EAST SEATTLE / BOYS & GIRLS CLUB PROPERTY vs COVAL PROPERTY (SUMMERWELL) vs

Builders asking for 14 houses on 2.88 acres – Granted ?????

Concerns:

SITE PLAN
2825 W MERCER WAY
PRELIMINARY PLAT
 PARCEL #2174502425
 CITY OF MERCER ISLAND WASHINGTON

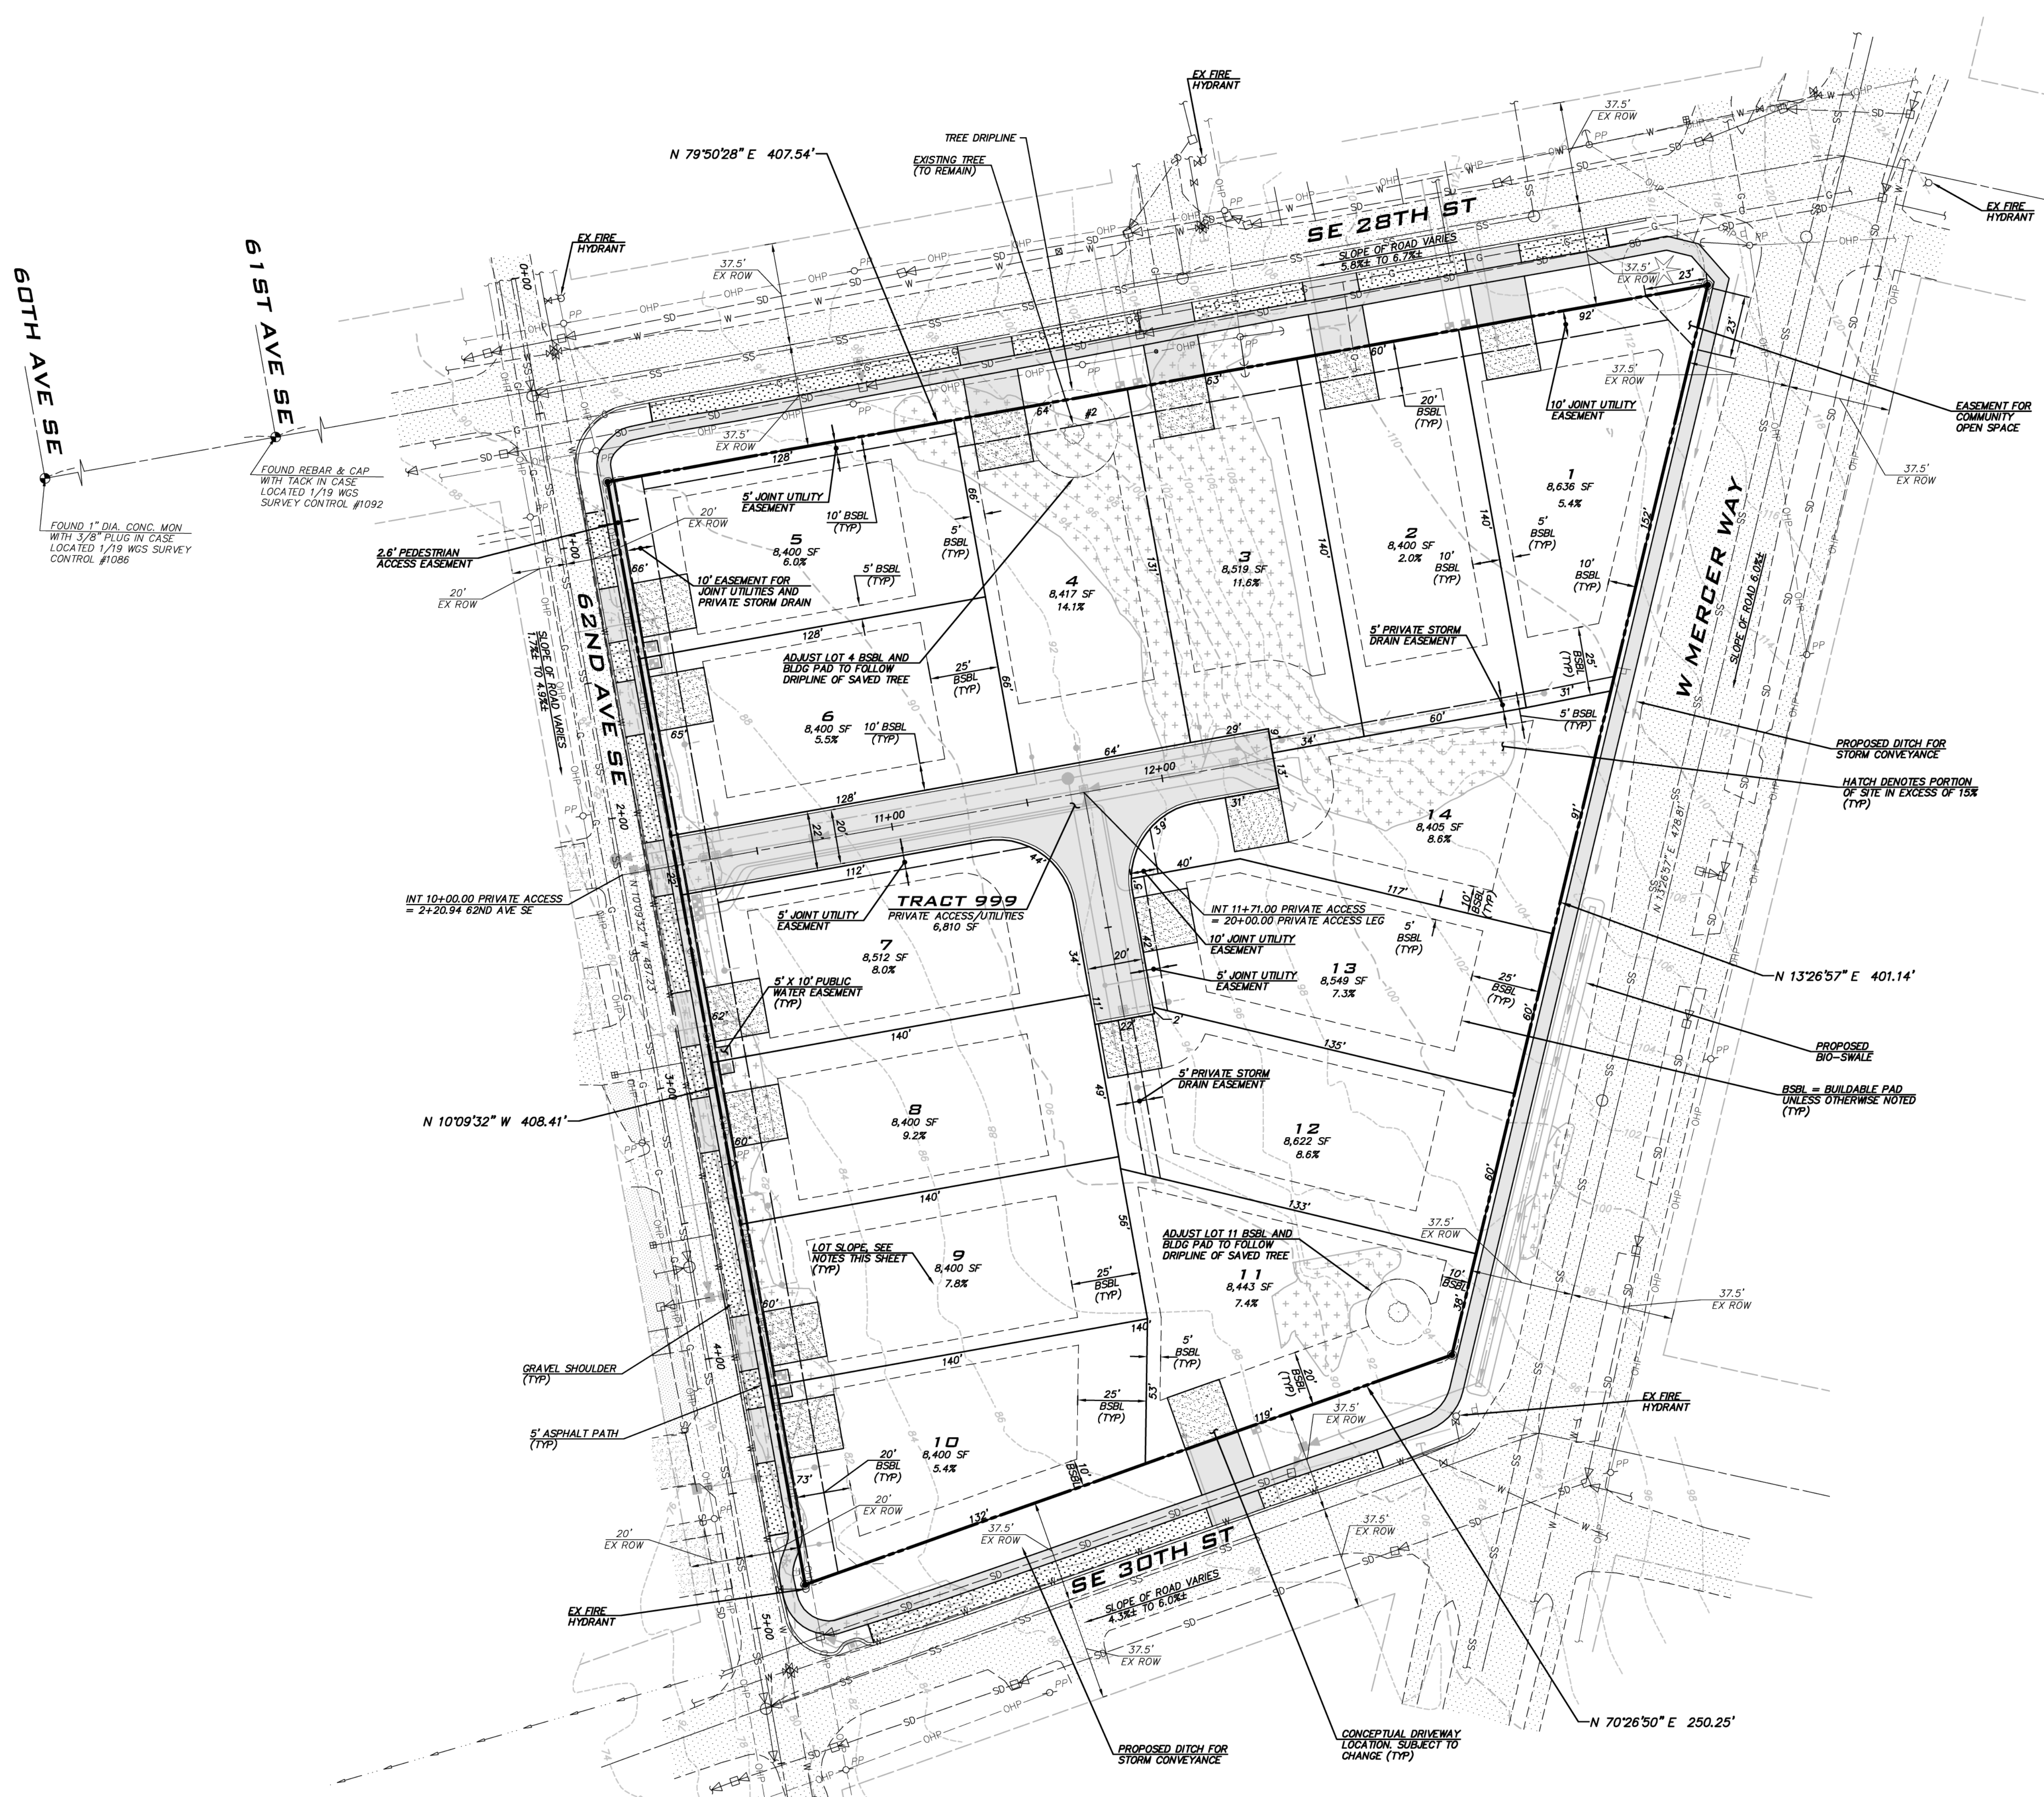
- Are there Sidewalks in development and along West Mercer Way
- Where are water retention ponds on each property (like we were required to put in at our home across the street from this project)
- Builders asking for 52% impervious services; Is the maximum usually 40%
- Is green triangle in upper right hand corner the only public open space.
- Is this where Owner says he will make a "valuable financial contribution" because he has" offered to provide a portion of the property to be improved with informational signage regarding... {East Seattle School's history}" Instead of declaring it an Historic Building

- Access to lots, Public and Emergency Vehicles – In the Public Notice of application I received 4/8/19 the description of request said the” lots would be accessed via a private street connecting to 62nd Ave SE”. I see a narrow street with access to lots 12-14 otherwise each house is accessed from existing streets.

- Not enough designated Parking – do all houses have a minimum of 2 car garages? Where do lots 12-14 park? Where do visitors and service people to all the homes park? Homeowners extra cars?
